Recommendation Report for Planning Permission for Works or Extension to a Dwelling

REF NO: WA/111/21/HH

LOCATION: Highdown
West Walberton Lane
Walberton
BN18 0QS

PROPOSAL: Erection of two storey front and rear extension with first floor rear balcony following demolition of existing rear conservatory.

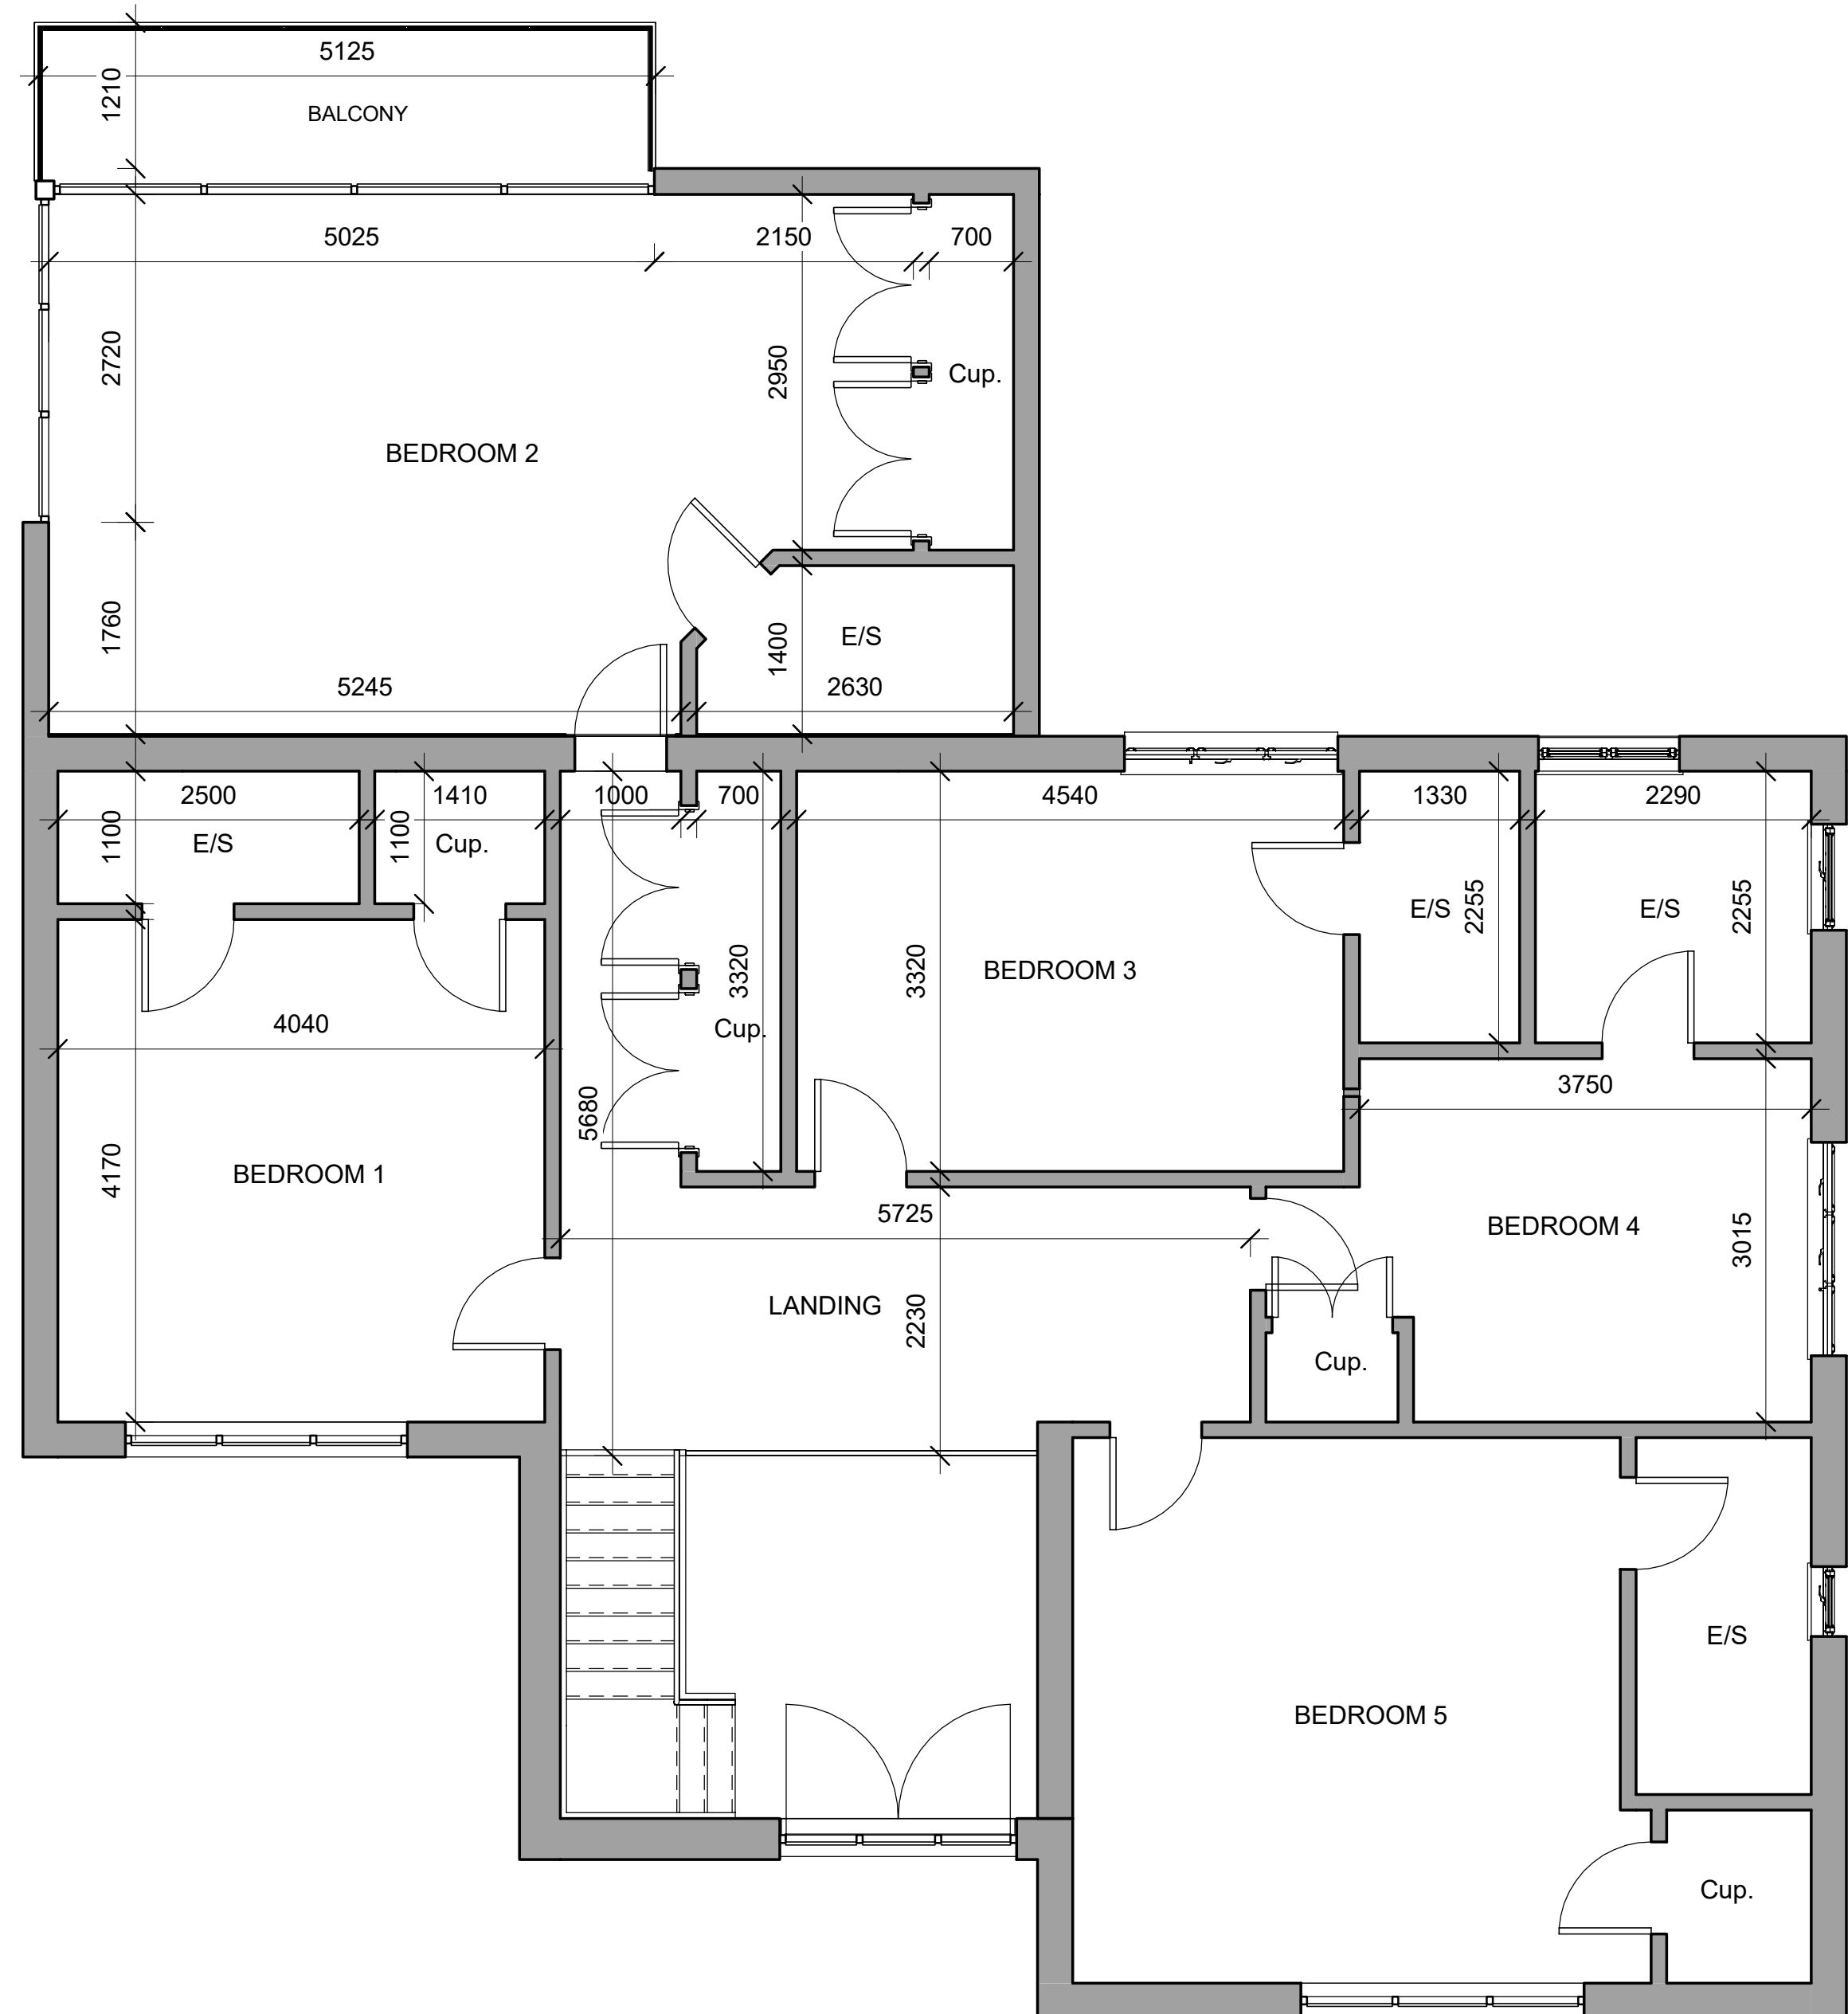
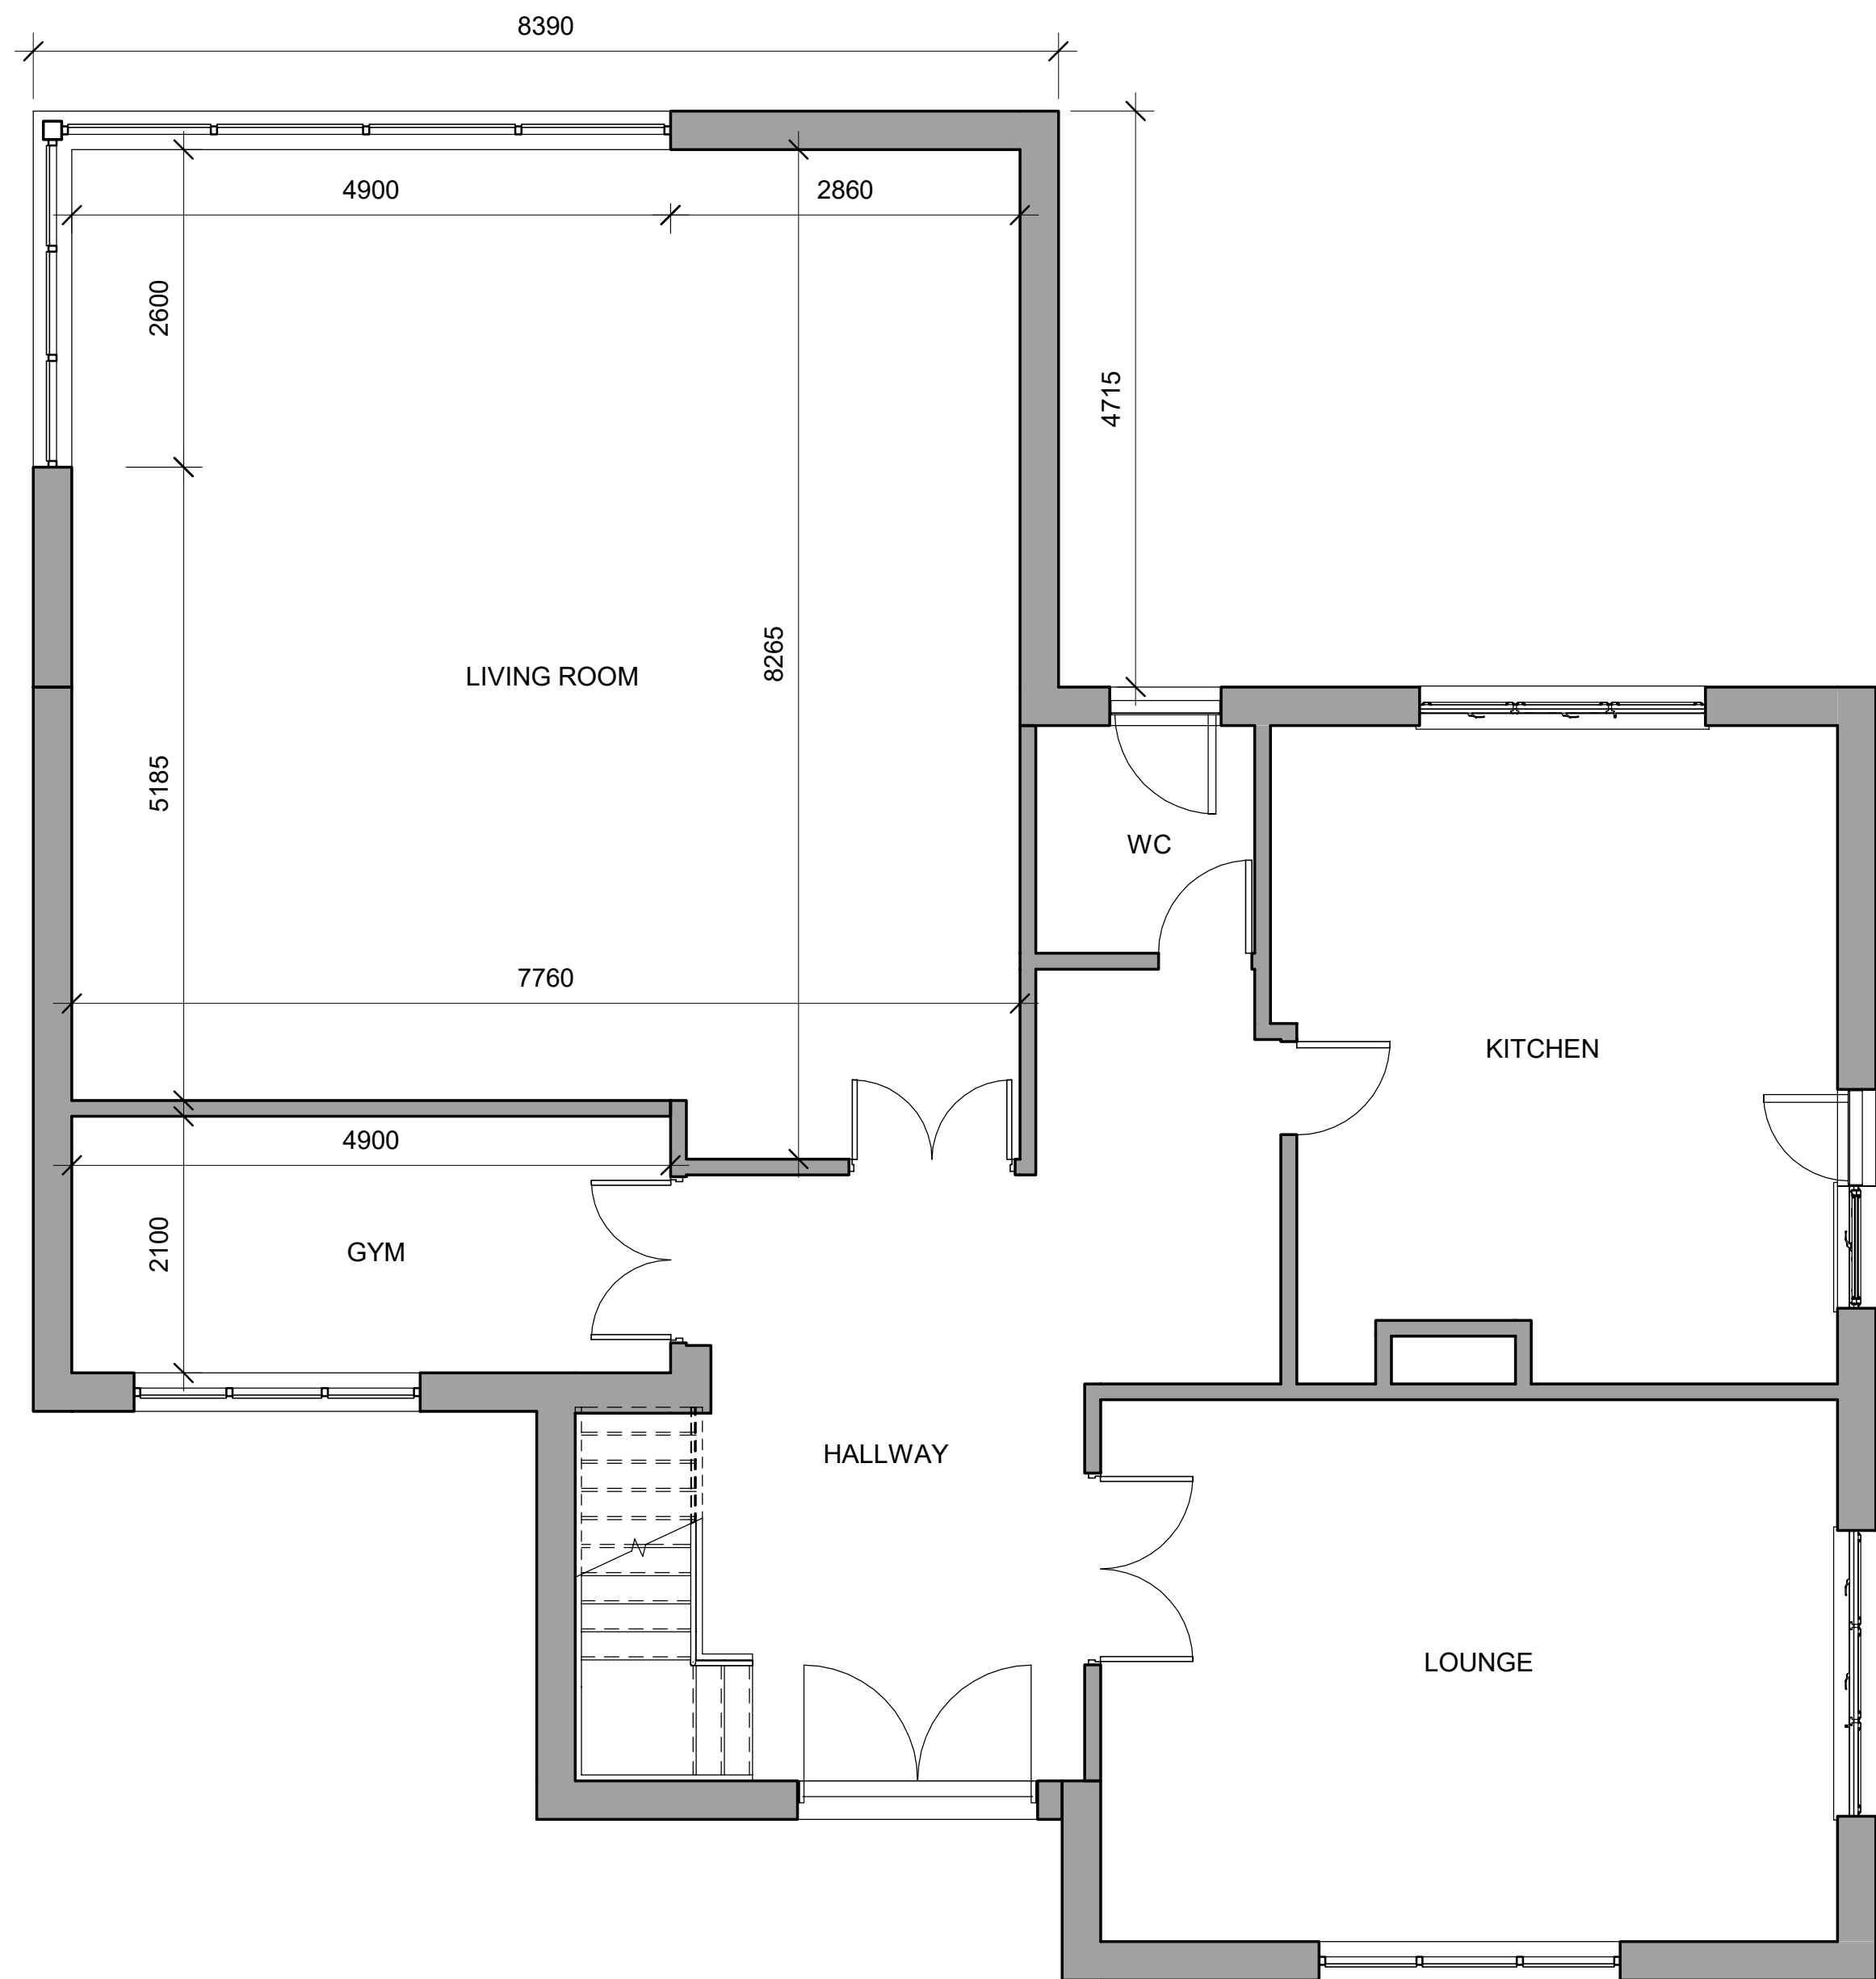
The front extension will have a depth of 3.3m and a width of 4.3m. This is not visible from the eastern side and retains a minimum of 7.3m to the boundary to the west. As a result of the separation between the front extension and neighbouring dwelling, it will not result in adverse overbearing or overshadowing.

There will be a large window to the first floor serving a landing although views will be over the front of the host dwelling and the addition does not result in adverse overlooking.

To the rear an existing conservatory will be removed and replaced with a two storey extension. This has a depth of 4.75m, with a width of 8.45m extending from the north eastern elevation along approximately half of the rear elevation.

CLIENT	Mr and Mrs Beach		
SITE ADDRESS	Highdown, West Walberton Lane Arundel BN18 0QS		
PROJECT TITLE	Proposed two storey front and rear extension and internal alterations		
STATUS	PRELIMINARY		
DATE	22nd Jul 2021	DRAWN BY	EL
DRAWING TITLE	PROPOSED ELEVATIONS		
SCALE	1 : 50 @A1	DRAWING NO.	P202

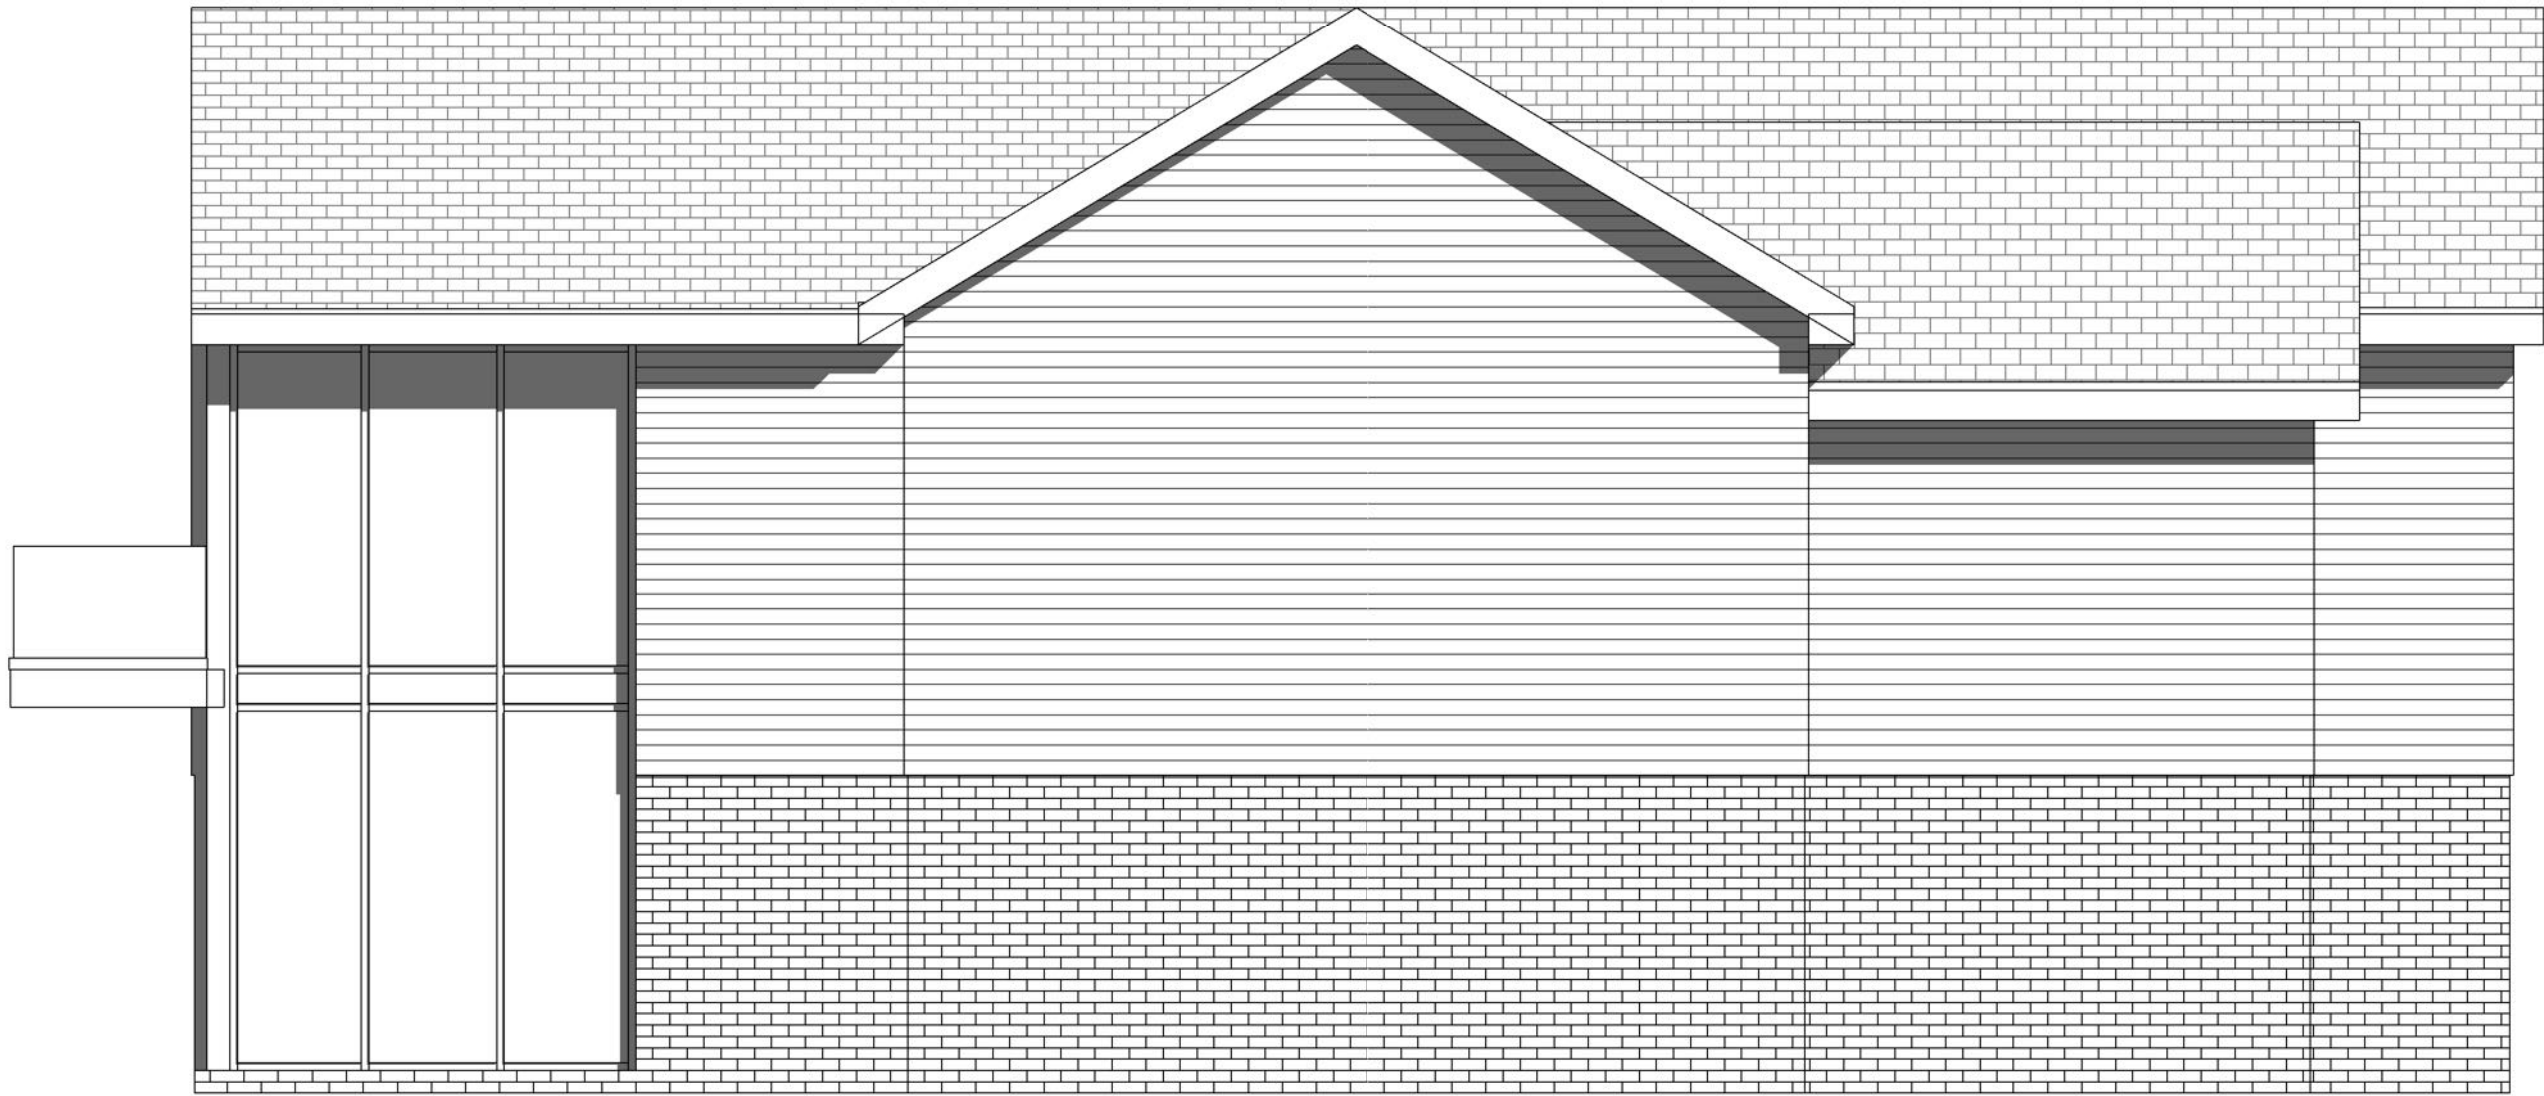
The two storey addition remains behind the principal elevation, set back by 1.3m which helps its subservience. It will have a pitched roof which is set below the ridge height, appearing well integrated and sympathetic in design to the host dwelling. With sufficient space retained to the front boundary the addition does not appear unduly dominant upon the front elevation and is in keeping with the design of the property.

There will also be a two storey rear extension although this element is not visible from the front of the property. Its height will match the eaves of the dwelling with a pitched roof meeting with the ridge. Its design appears integrated with that of the main dwelling.

The windows to the property will be replaced which responds to the existing elevation in terms of their positioning. The external materials will alter with cladding proposed to the first floor of the dwelling. The

To the north west elevation, the extension will have large glazed windows at first floor where it then alters to form a balcony. The host dwelling is located at an angle and the windows will provide views over the garden of the neighbouring dwelling. There is also potential for some views to the rear of the neighbouring dwelling which features a conservatory, when looking at a 45 degree angle. However due to the angle that the development is positioned combined with a 25m gap between the side elevation of the extension and the side of the conservatory this is not considered to result in significant overlooking. The balcony to the rear of the first floor extension would have a depth of 1.2m. To the west, this would provide similar views to that achievable from the side facing windows. Whilst to the eastern side elevation, there are large trees which run along the boundary providing sufficient screening to ensure there is no adverse overlooking. There is also around 27m gap retained to the neighbouring property. As such the balcony is not considered to give rise to adverse views towards the neighbouring dwellings. With no properties to the rear and 50m retained to the rear boundary, there is no harm upon the rear.
